b. Traffic Engineer Tom Errico

I have reviewed the June 10, 2010 application and find it to be acceptable with the following comments.

2 SITE PLAN
SCALE: 1" = 10'

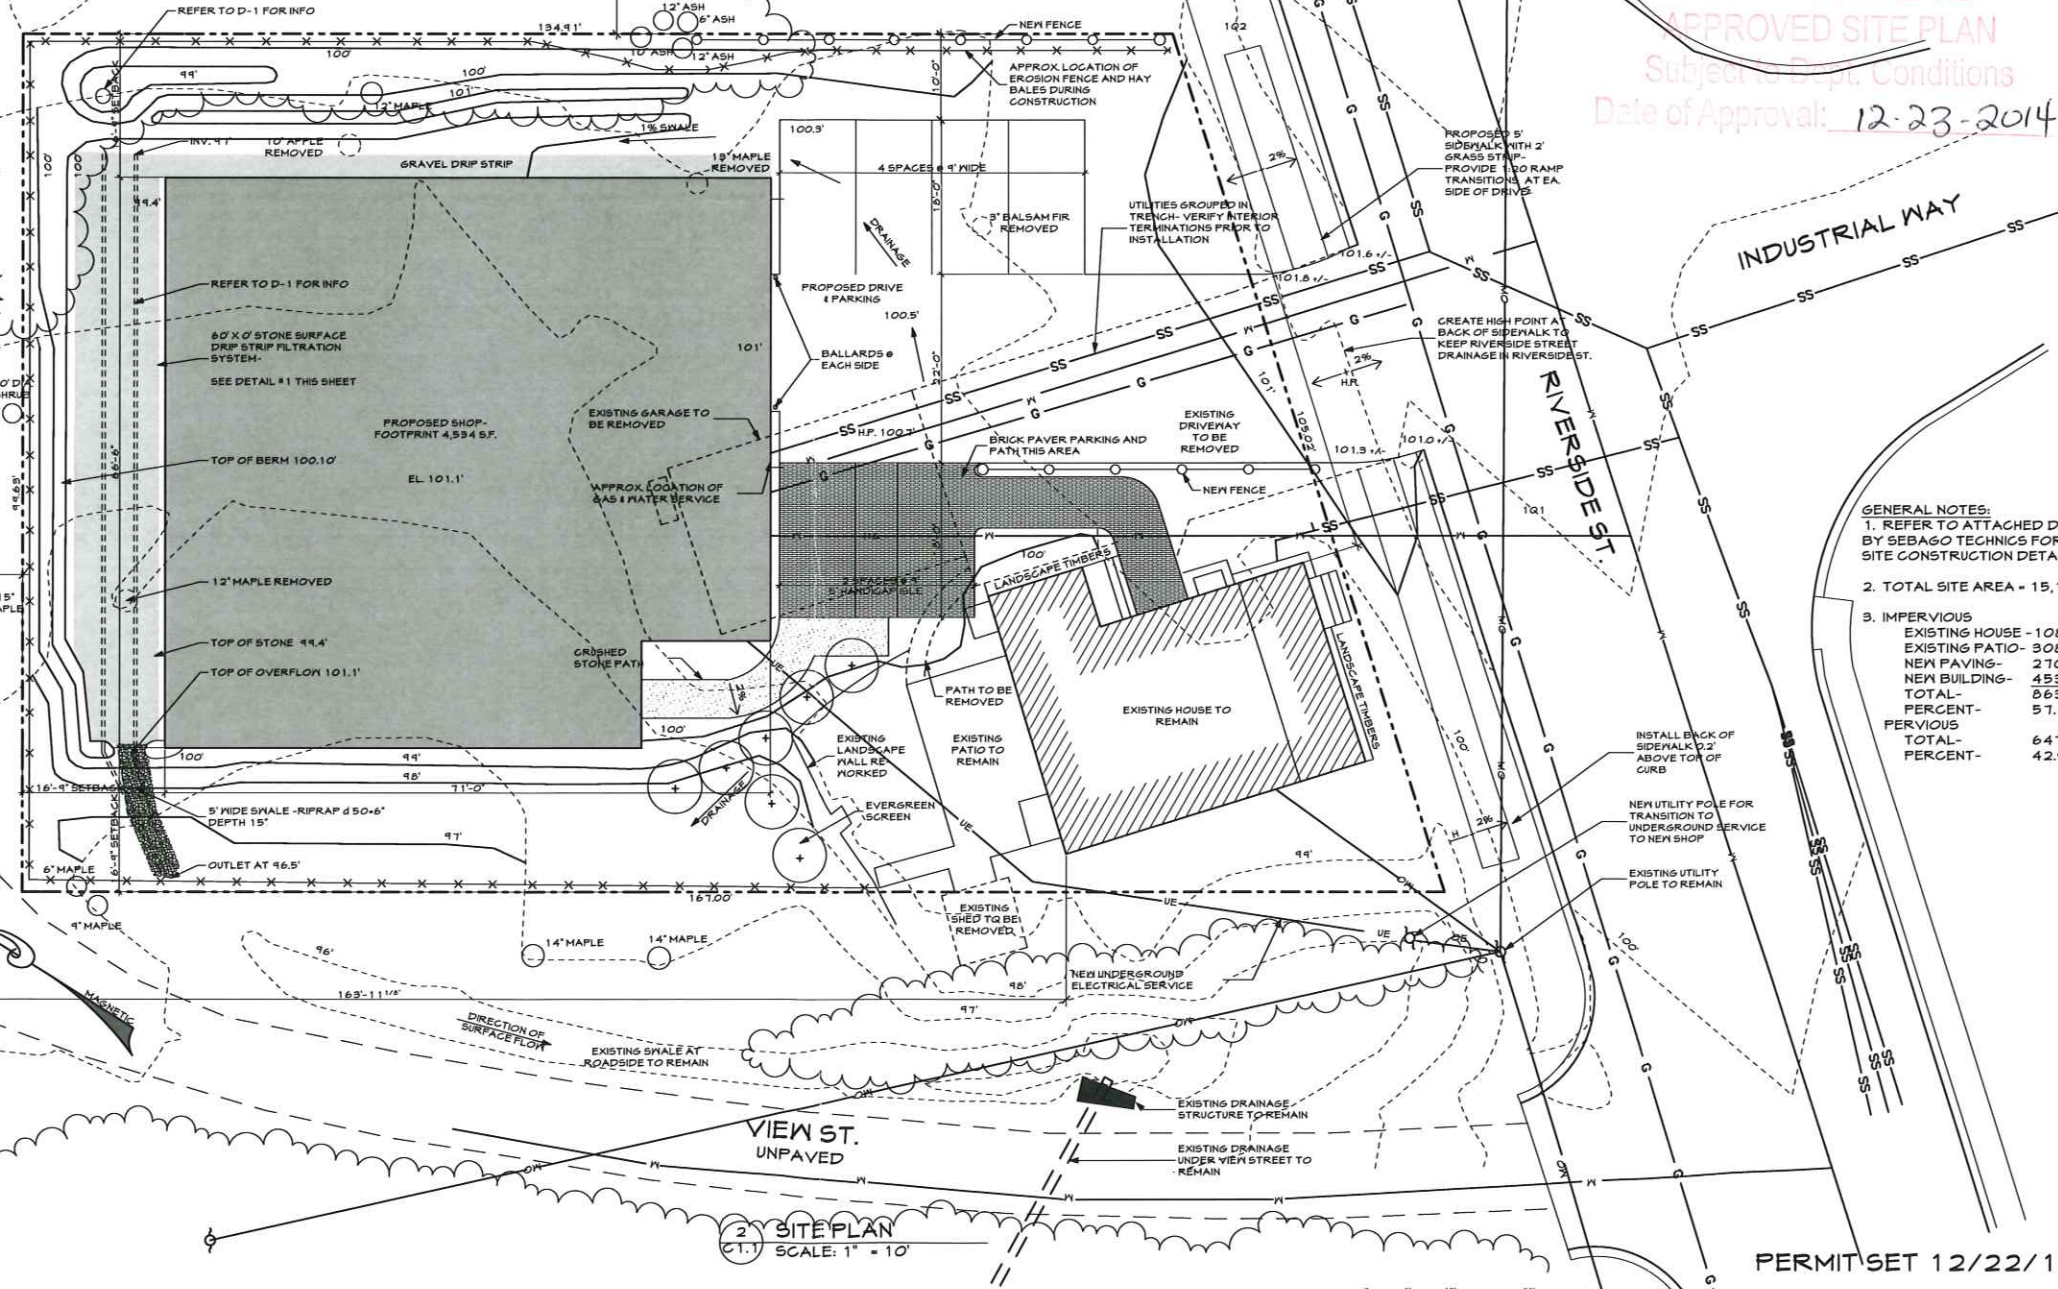
- v. The applicant is requested to show utility (water, sewer, electric) locations and details for installation. Details for work within the road right of way can be provided upon request.

- i. The proposed parking aisle width is 20 feet and does not meet City of Portland standards. The applicant should provide justification for a technical waiver from the standard.
- ii. It is unclear how wide the proposed parking spaces will be. This should be clarified.

PROPOSED DRAINAGE PLAN

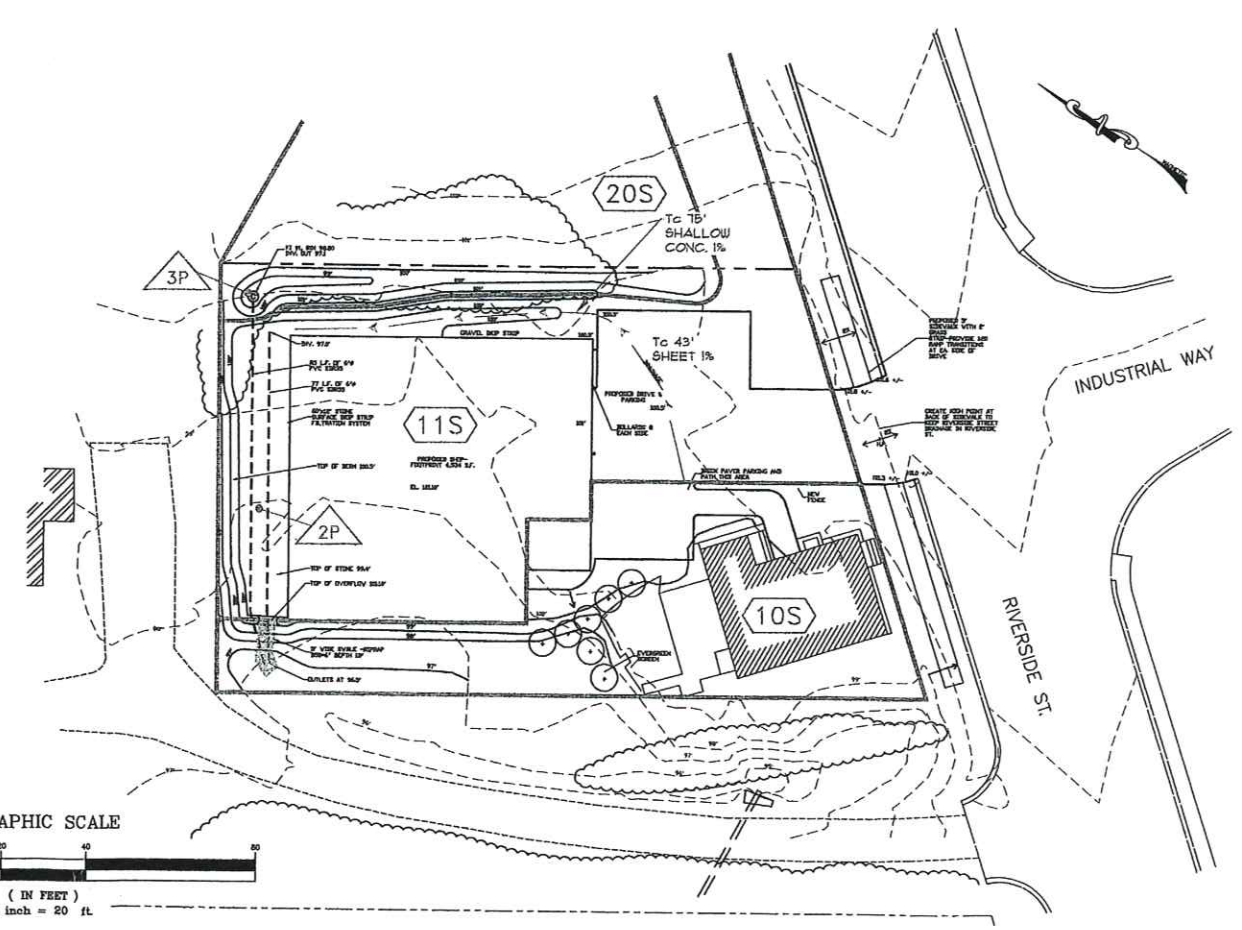
Applicant needs to provide a stormwater analysis that includes a description of the new impervious surface being created and a management plan for how drainage discharge will occur and the method of any proposed treatments.
